# CITY OF ALBUQUERQUE

RE: **El Manzanal Subdivision** - 704 Griegos Road, NW  
**Conceptual Grading & Drainage Plan**  
**Engineer's Stamp Date (none) (File: F14D069)**

PRELIMINARY
GRADING AND
DRAINAGE PLAN

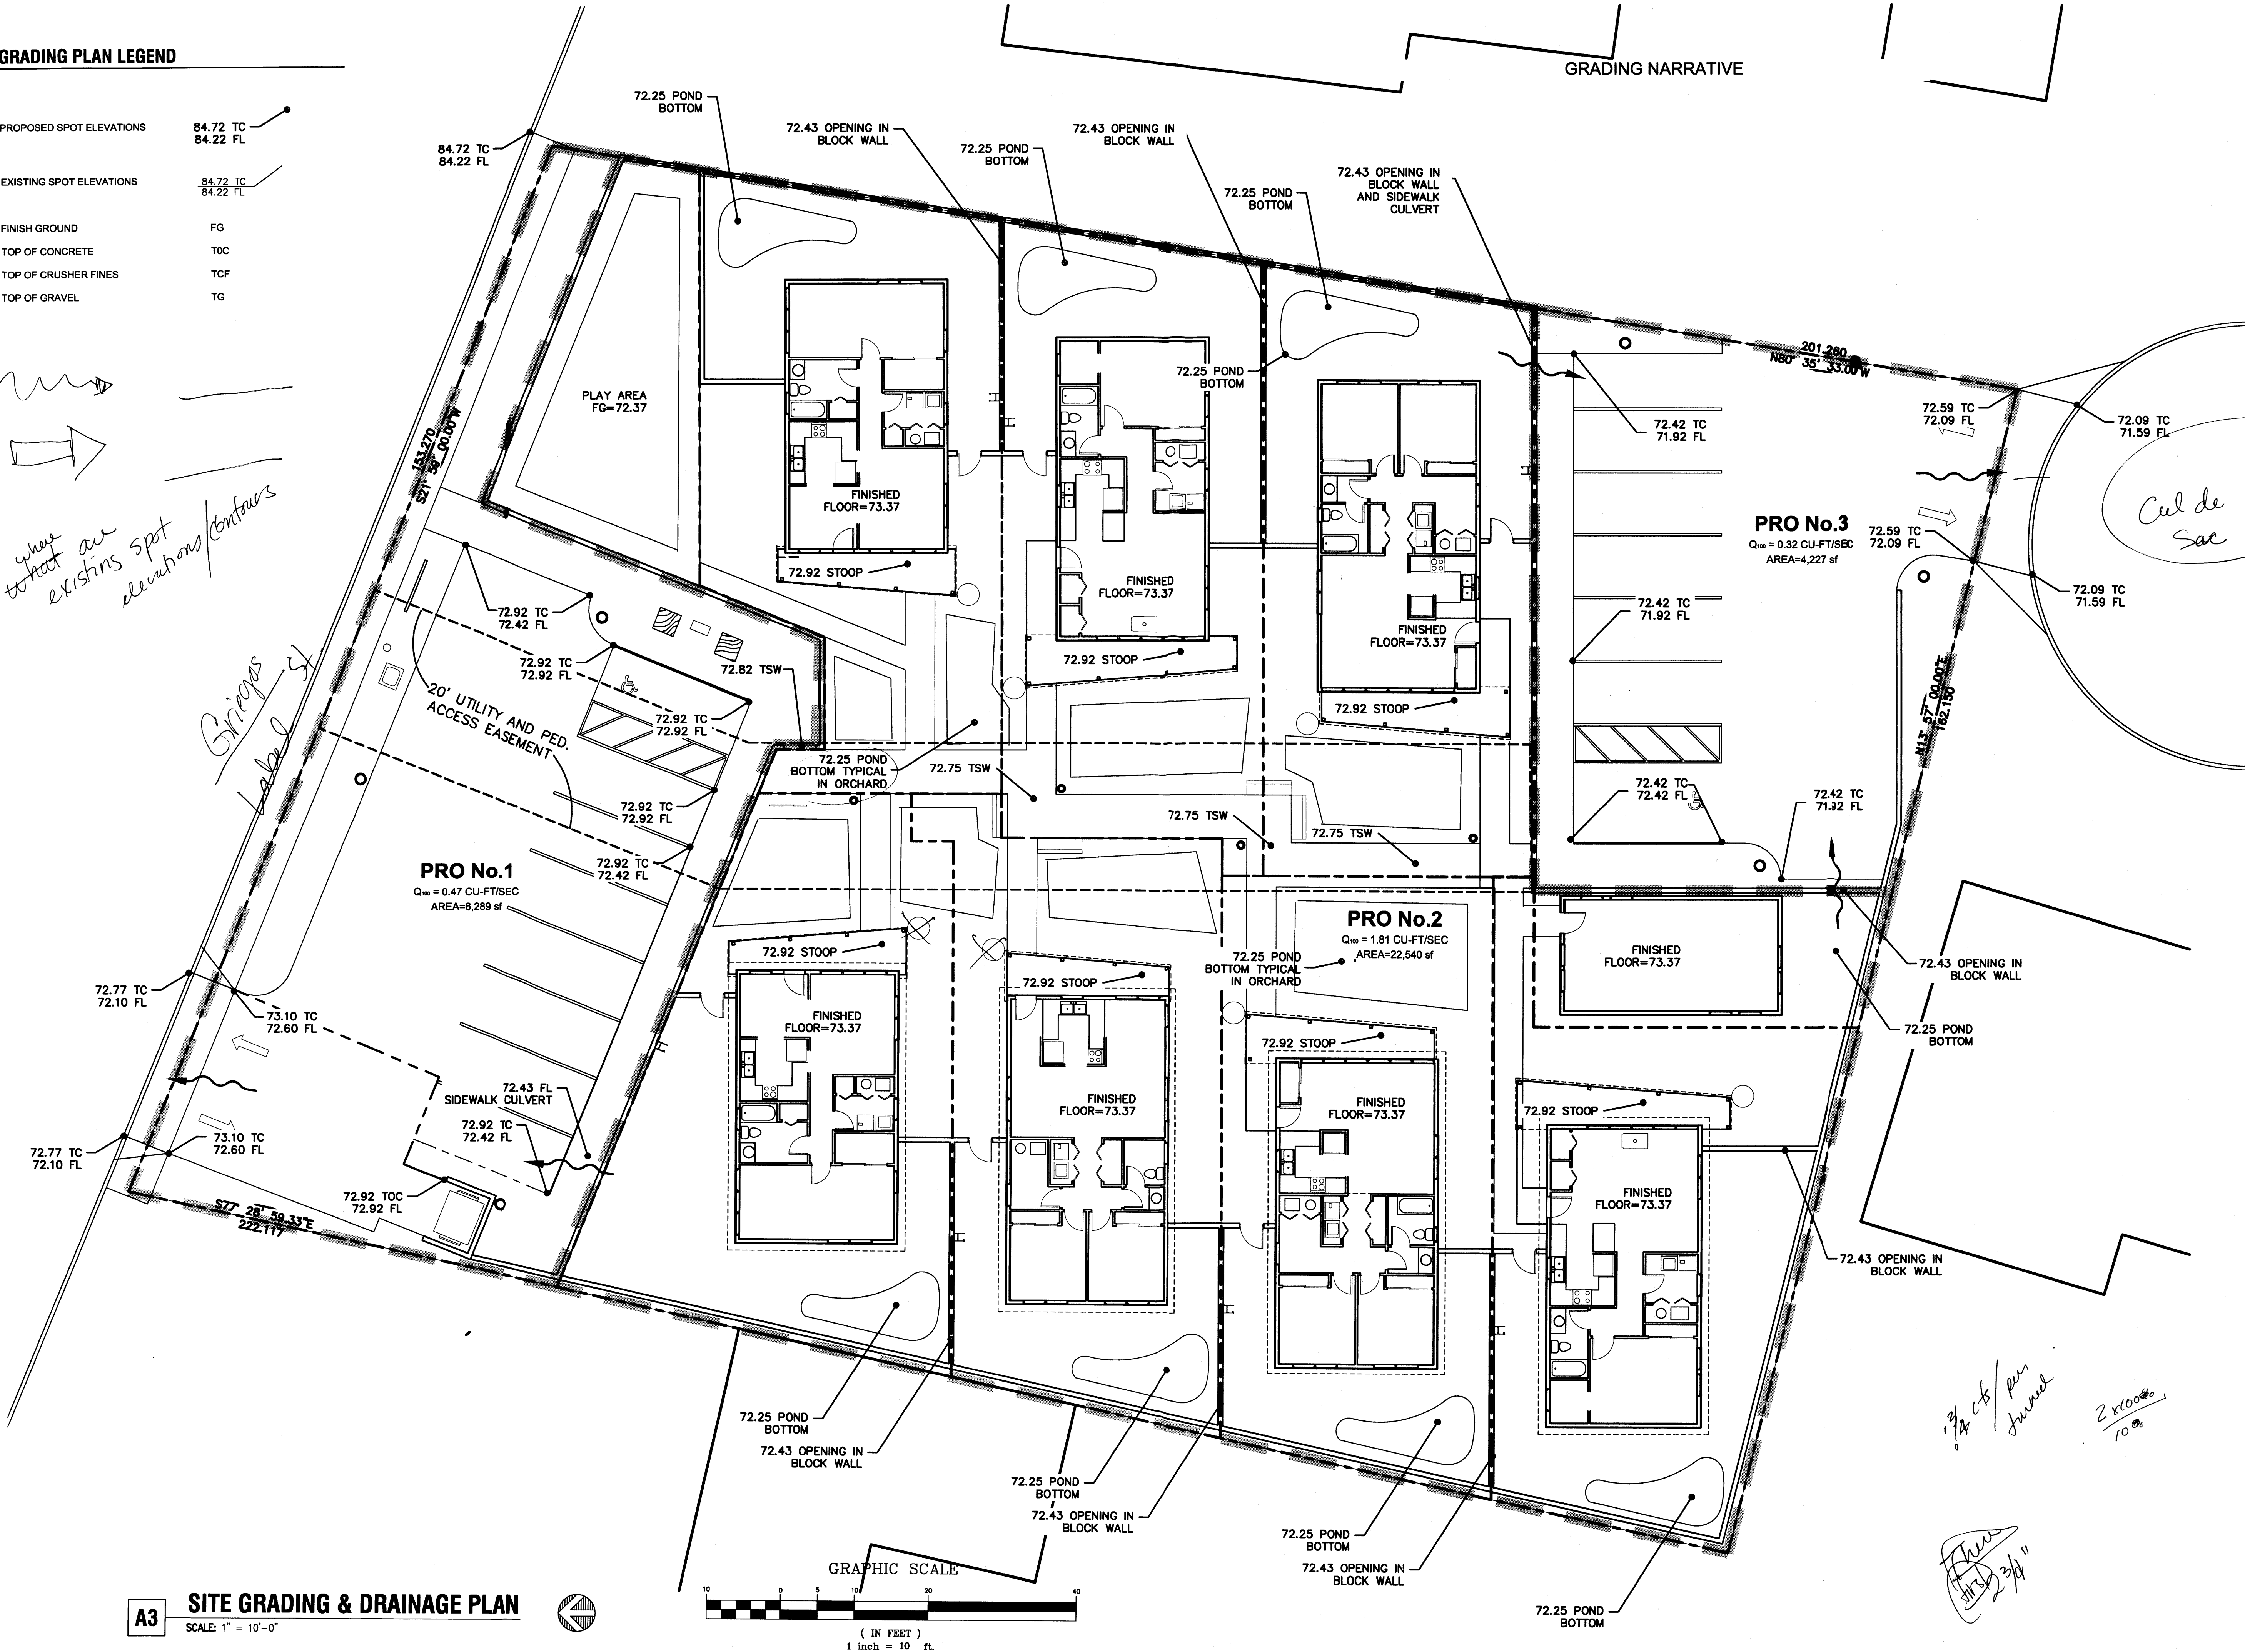
1. Show existing spot elevations/ contours on site and adjacent to property
2. State how the first flush is to be managed.
